April 26, 2017

Re: Status of Improvement Permit & Well Permit Applications # 17-5-40947

SITE PLAN APPROVAL

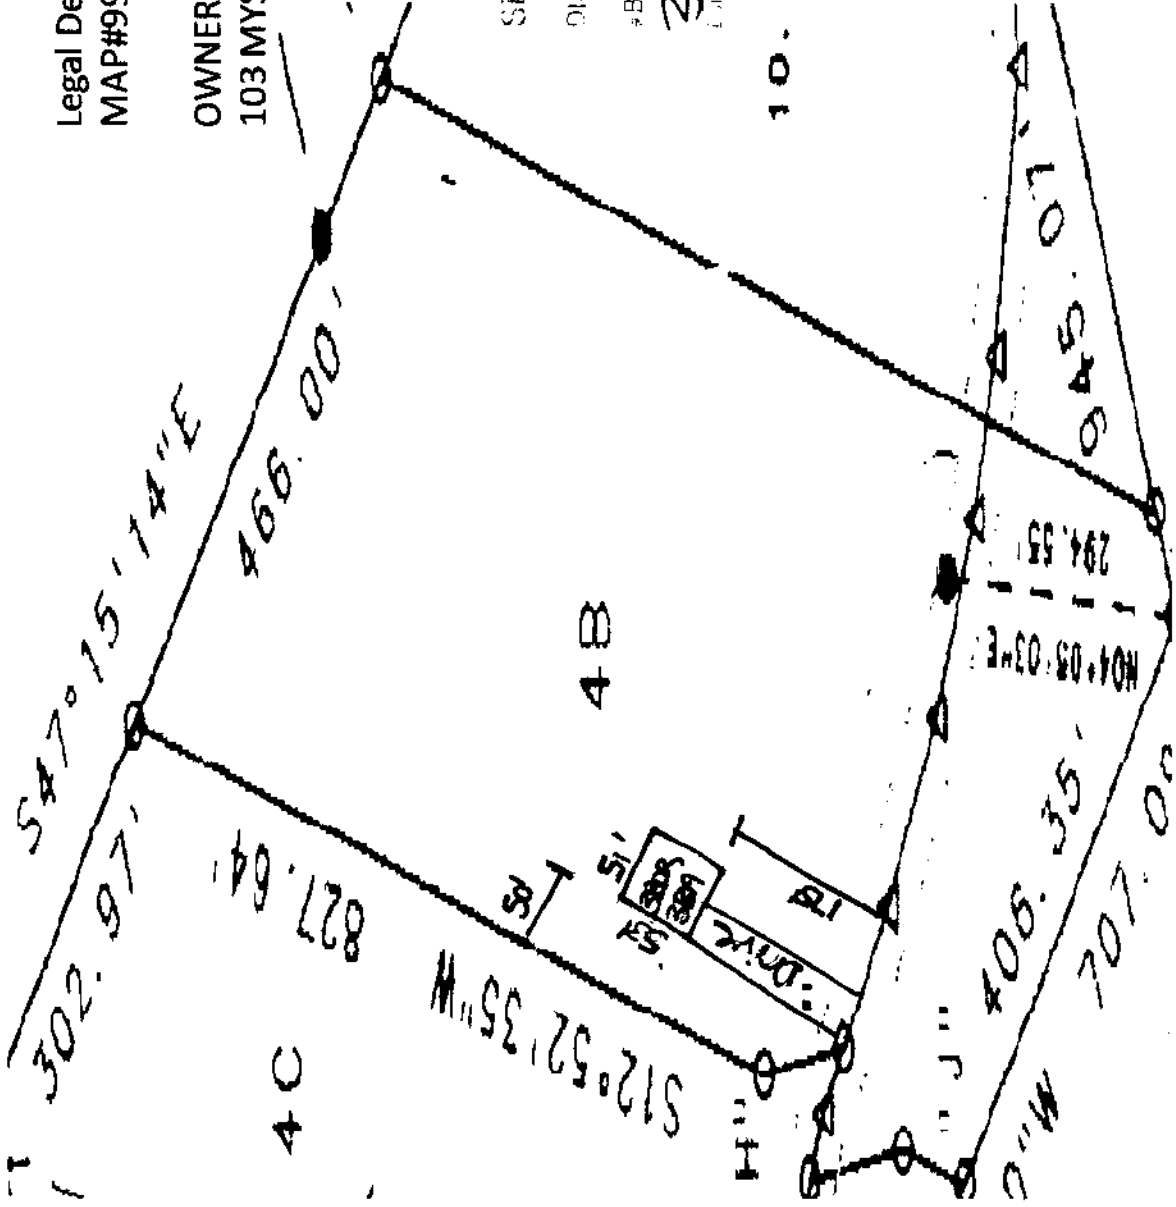
- 1. Use pink flags to mark property lines and irons that are set by surveyor need to be visible (\$25.00 fee incurred)**
- 2. Use orange flags to mark house corners (\$25.00 fee incurred)
- 3. Directions not clear to property (\$25.00 fee incurred)
- 4. Property needs only brush or vegetation removed
- 5. Driveway not shown on site plan
- 6. Backhoe pits required**
- 7. Other – No proposed septic or well area.**
